Notification for prior approval under class C for a change of use from a shop (Class A1)
to a restaurant/cafe (Class A3)
51 Sea Lane Rustington

Thank you for your internet representation made on 8th September 2017 which has been recorded as '**an objection**' with the comments as follows:

North Elevation: Side View of 51 Sea Lane

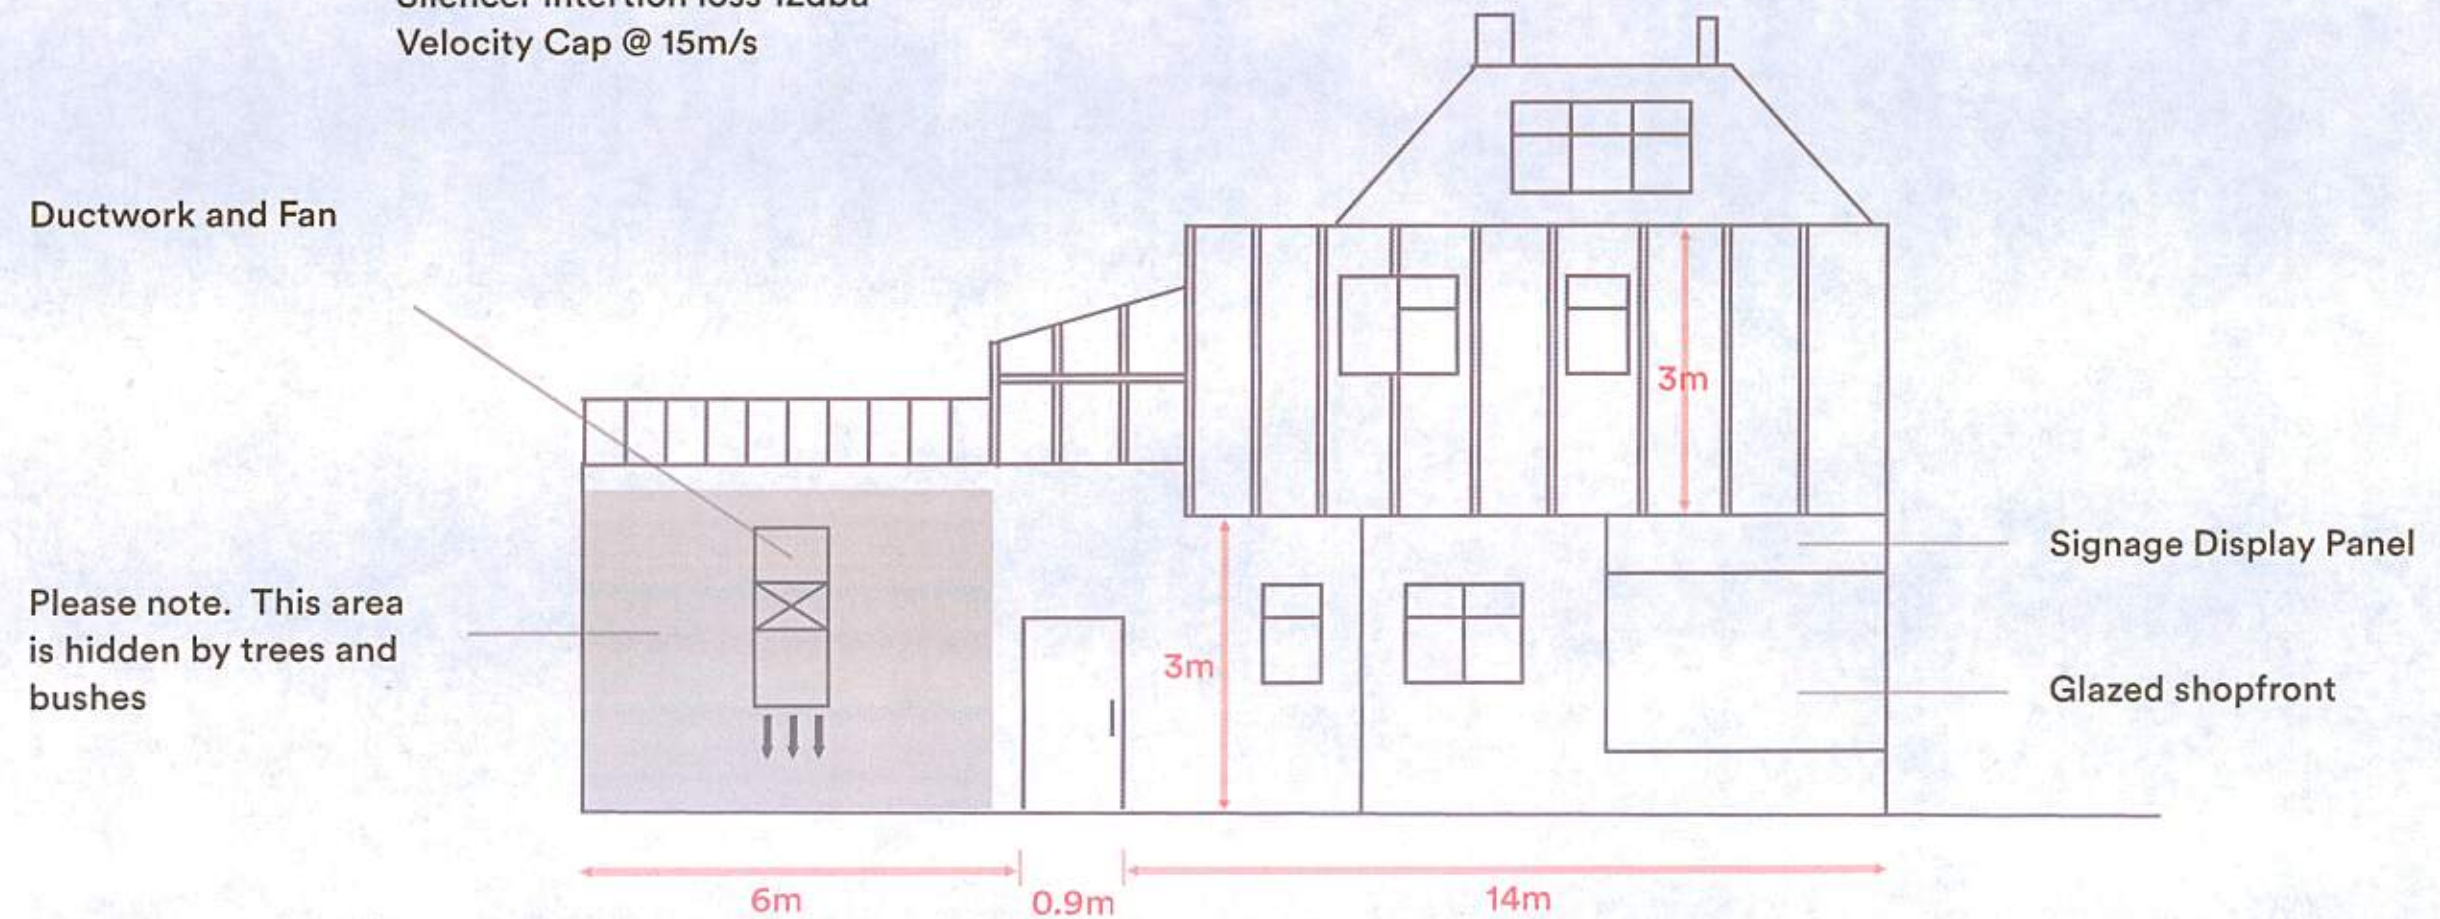
New Extractor Fans. The positioning of the extractor fans on the North elevation would direct any noise and smells directly into a private residence, i.e. The Old Barn (thatched).

APPENDIX TWO:
DRAWING SHOWING PROPOSED REFUSE FACILITIES

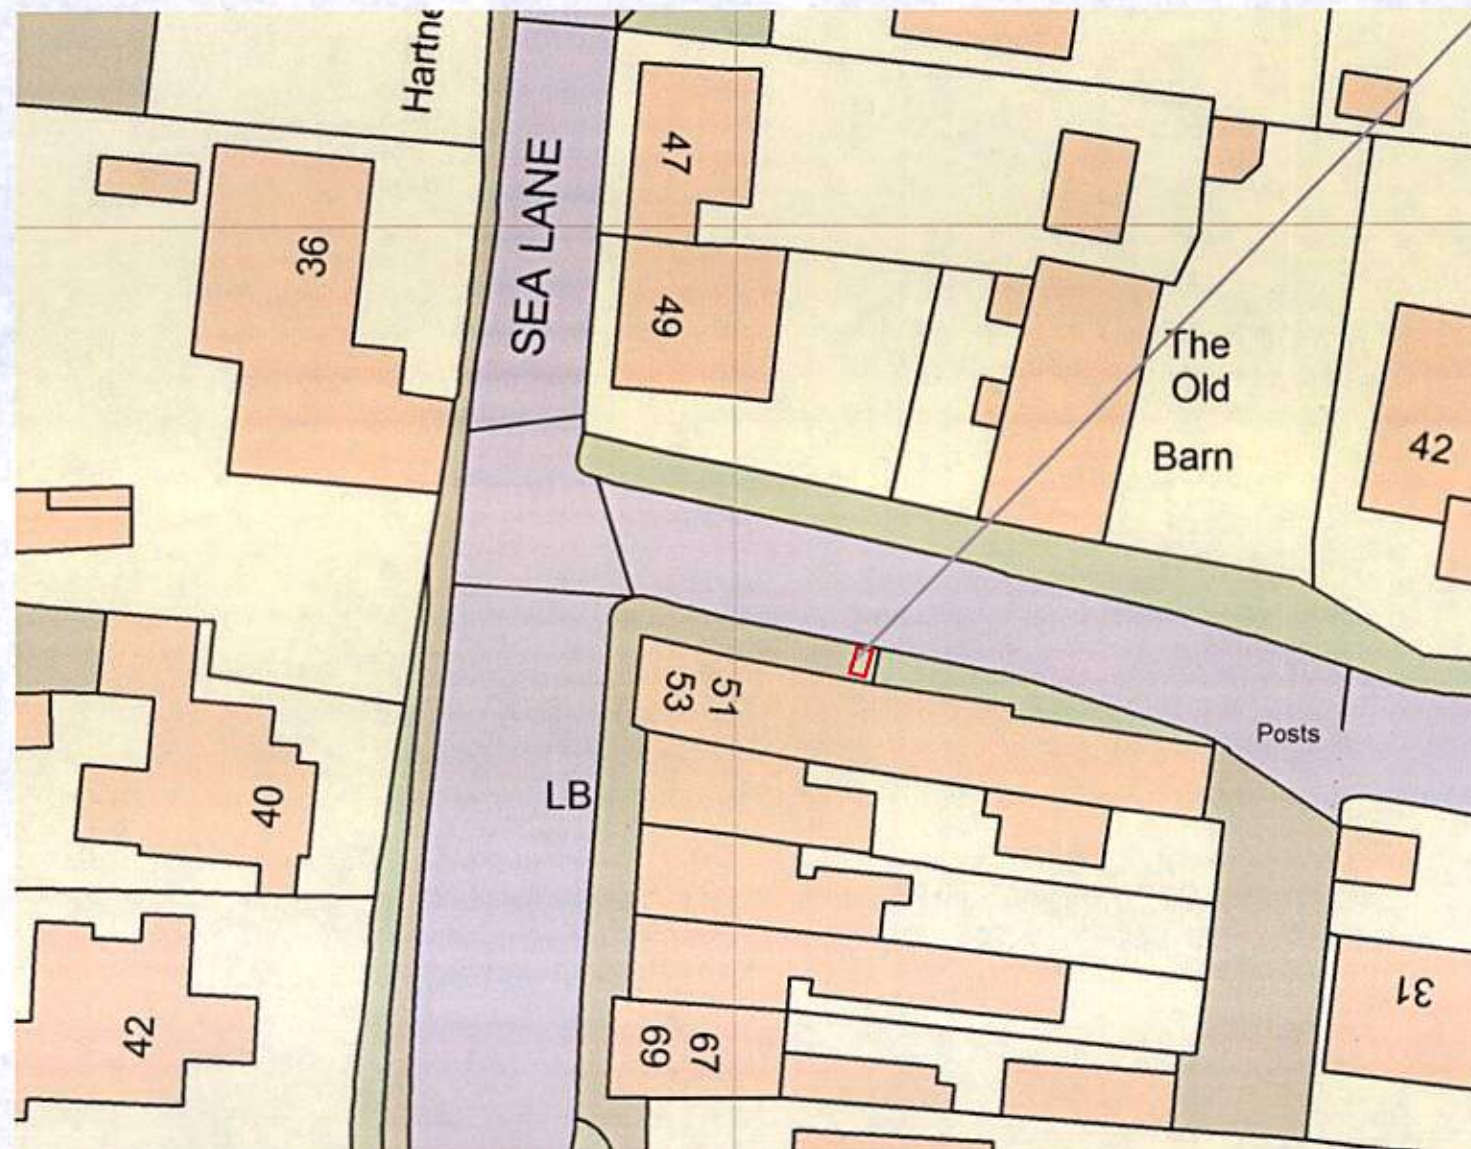
Road Obstructions. The access for any delivery vehicles and waste collection vehicles is very limited and could lead to either Sea Lane or Cudlow Avenue being obstructed.
